Town & Country Planning Act 1990 (as amended)
Town and Country Planning (Development Management Procedure) (England) Order 2015
Application for approval of details reserved by condition imposed under planning permission
BR/270/16/PL relating to condition No, 3 (surface water drainage), 4 (arboricultural protection
measures), 5 (construction site set up), 6 (materials of external walls and roofs), 7 (landscaping
scheme) & 10 (lighting)
Villa Maria Campbell Road, Bognor Regis,

Notification regarding the above application:

Condition Number 6

Proposed Material Elevation

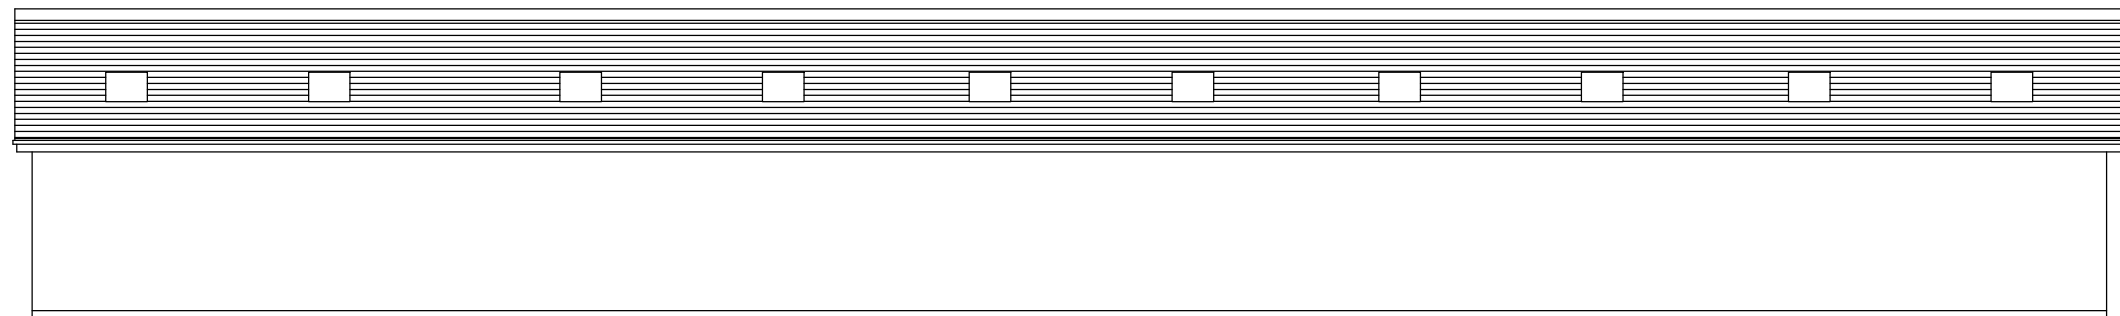
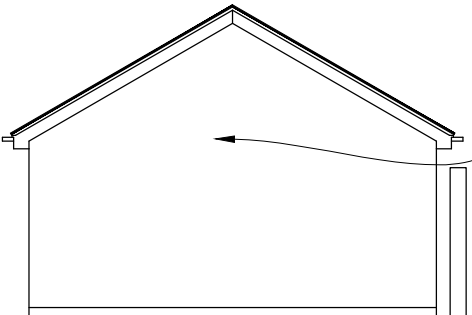
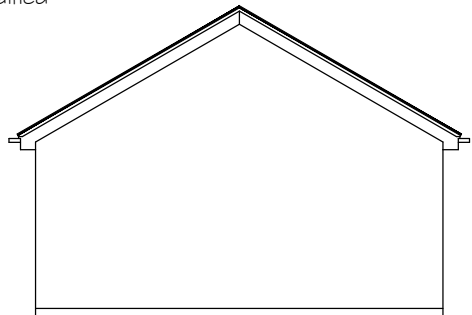
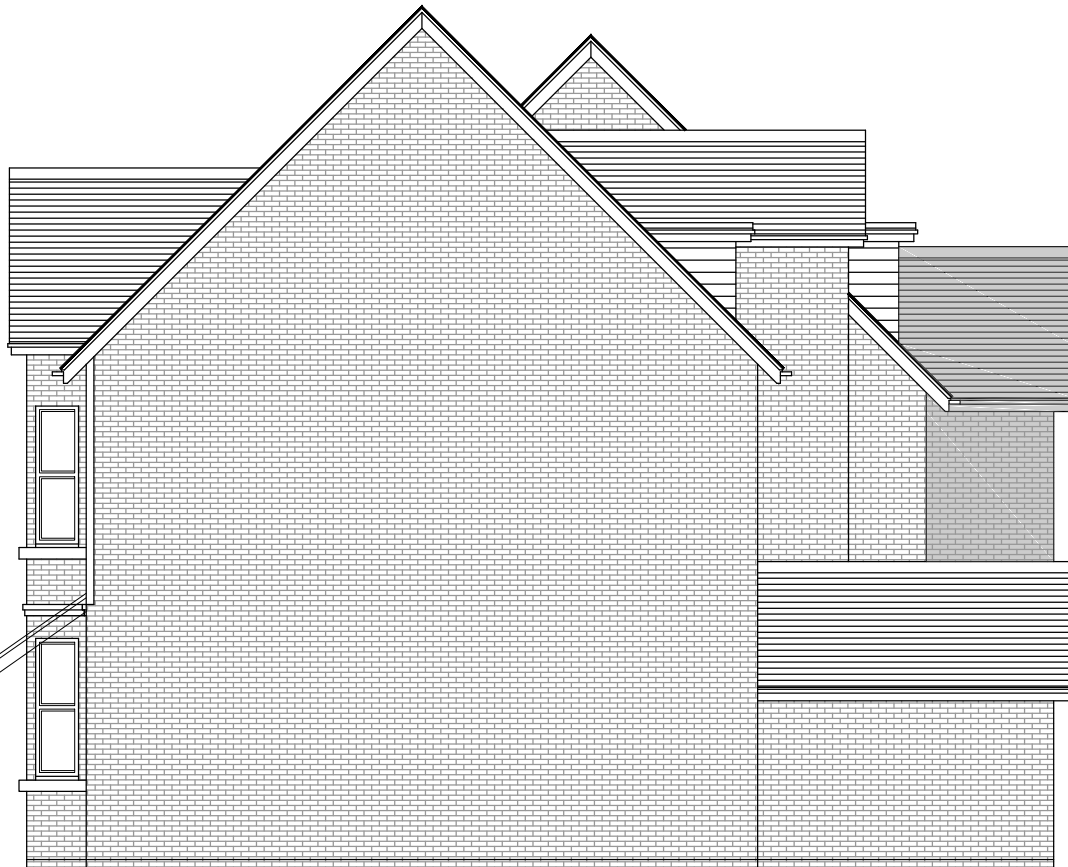
In respect of the new single storey block of accommodation, you have provided a list of materials namely:

- (1) External Walls - Render (blue)
- (2) Roof - Marley Modern Interlocking Concrete Tile (Grey)

Following our confirmation that samples would not be required, you agreed on 08/10/17 to docdeci

instead provide colour images. However, none have been received. Therefore, the local planning authority is not able to properly assess the impact of the new build elements on the character or appearance of the area. For this reason, this condition is only discharged in part and you must provide either samples or colour images with a new application in order to discharge the part of the condition that relates to the new build.
